From: Kate Fielden <[REDACTED]>
Sent: 23 August 2019 17:14
To: A303 Stonehenge <A303Stonehenge@planninginspectorate.gov.uk>
Cc: 'Dr. Dr George M M REEVES' [REDACTED]; 'Charlie Hopkins'
[REDACTED]
Subject: Presentation by Dr Reeves at ISH 10 on 29.8.19

Notes to accompany Slides/Presentation on fundamental Issues of Groundwater Conditions relating to the proposed A303 Stonehenge Tunnel by Highways England. August 2019.

By Dr. GM Reeves

Barrois' Sponge Bed/Whitway Rock Stratigraphic Level:

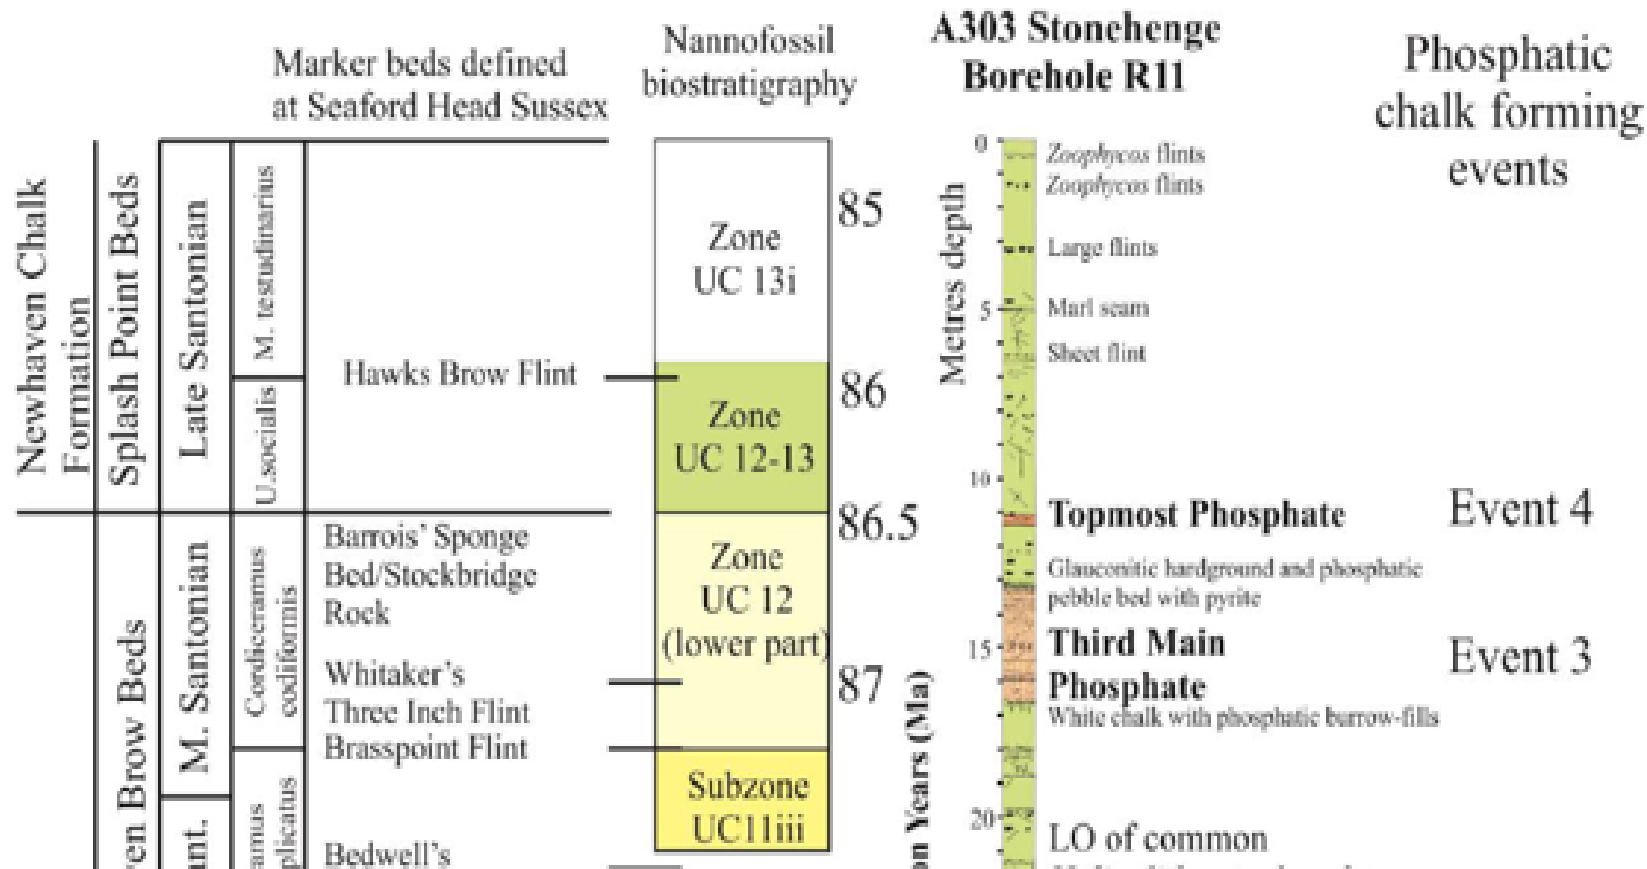
8. The Barrois’ Sponge Bed/Whitway Rock horizon, its stratigraphical position and hydrogeological relevance along the proposed tunnel route.
The stratigraphic level of the Whitway Rock in the Upper Seaford Chalk, approximately 5 metres below the base of the overlying Newhaven Chalk can be seen in this figure from Mortimore et al. 2017. Note: Borehole R11 is a significant distance west of Stonehenge Bottom: see Section in Slide 10, from AWM report.

Figure 2 Chalk Stratigraphy with Tunnel and Chalk Rock Elevations (adapted from Mortimore (2012))

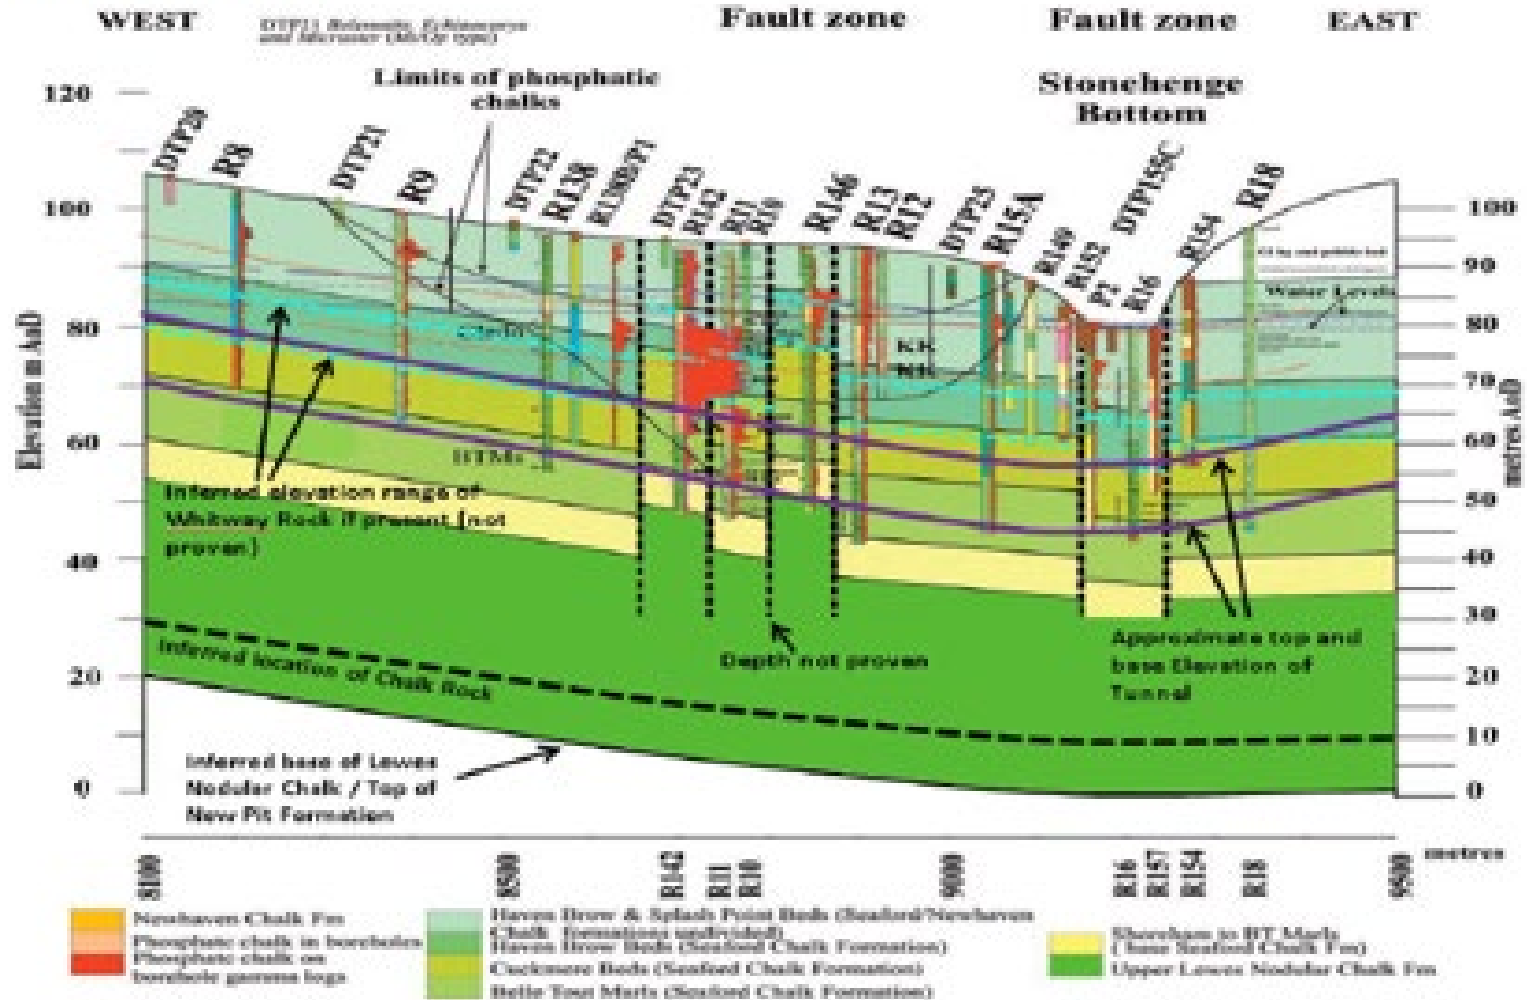
10. Critical Review/Discussion on AWM figure from “Groundwater Modelling Report”.
This section (from the AWM Groundwater Modelling Report) shows that the author(s) were aware of the possible importance of the Whitway Rock horizon and associated groundwater conditions to their model, and the tunnel line.
This again emphasises the absence of the necessary detailed groundwater investigations at appropriate depths and detail to adequately characterize these significant groundwater conditions as the “possible” horizon which controls west to east groundwater movement and is not considered in, or important to, the groundwater models.

BGS GeoIndex Database:

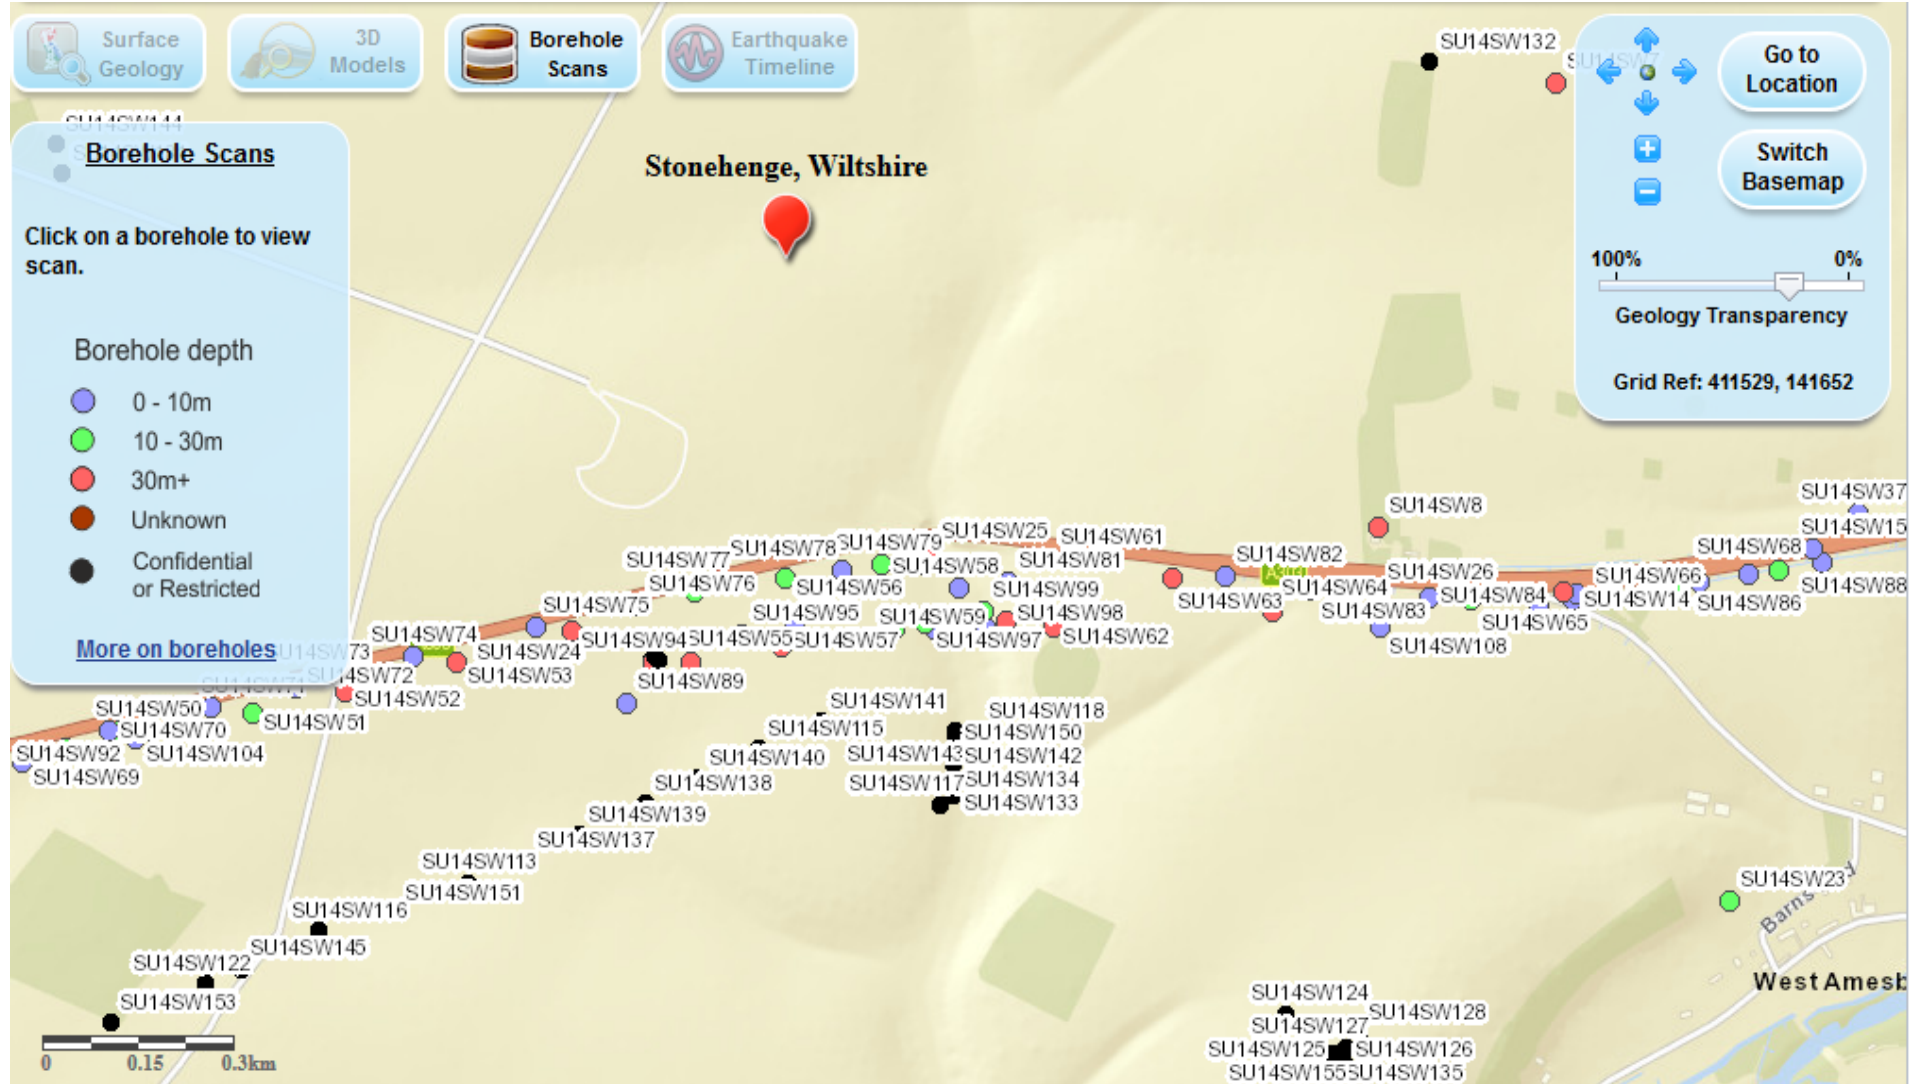
The current BGS GeoIndex Borehole Database Borehole Locations are shown on this figure. "Commercial In Confidence" borehole logs (which are numerous) and unavailable are shown in Black.

Borehole R20

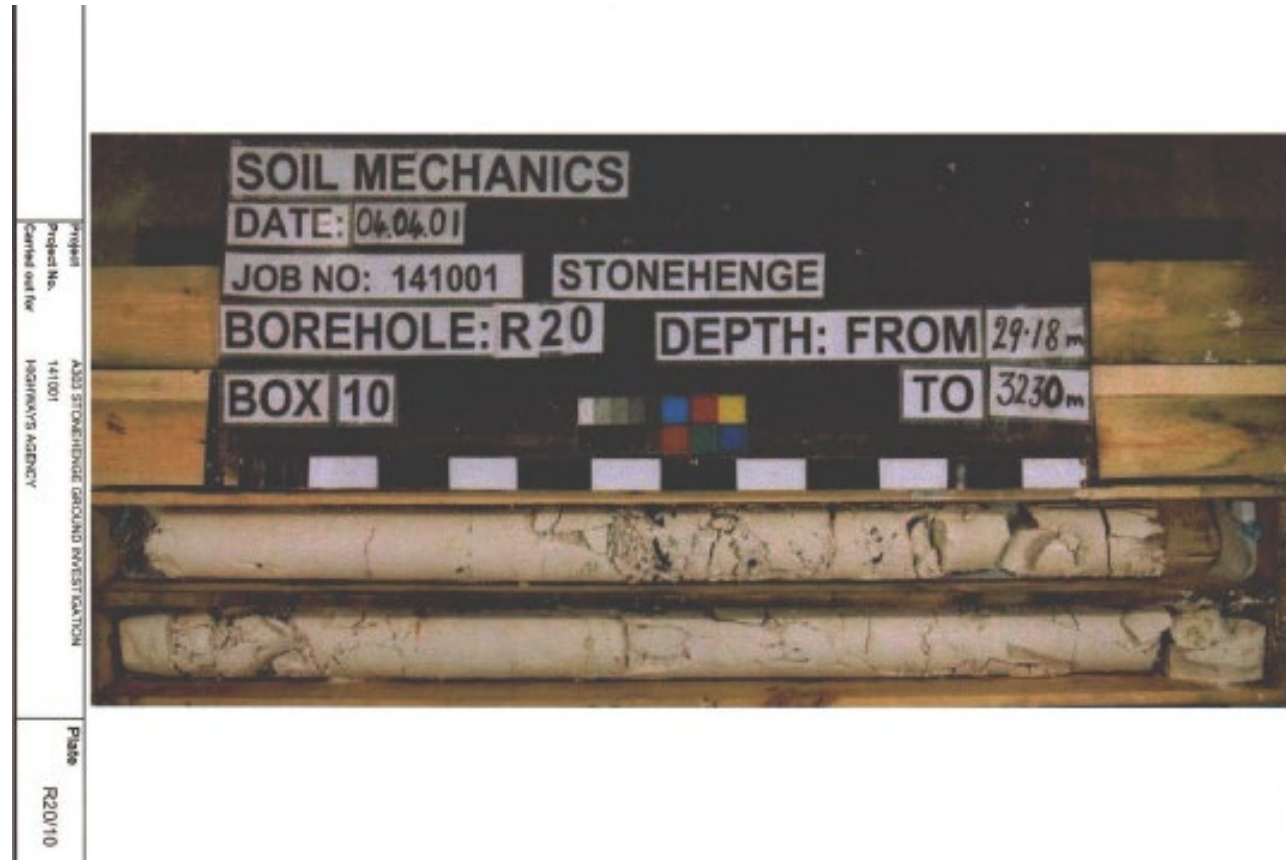
From about 29.00m to the suggested level of the Barrois' Sponge Bed at 32.56m, as identified on the 2001 borehole log, core box photographs and geophysical logging of Borehole R20 (to the east of Stonehenge Bottom), a zone of heavily fractured Seaford Chalk (extending from 74.68m down to 71.30m AOD) can be identified. Along this fractured zone, groundwater flow is concentrated, moving from the recharge area to the west and Stonehenge Bottom, to discharge into the River Avon via the Blick Mead area and the Amesbury Abbey Springs.
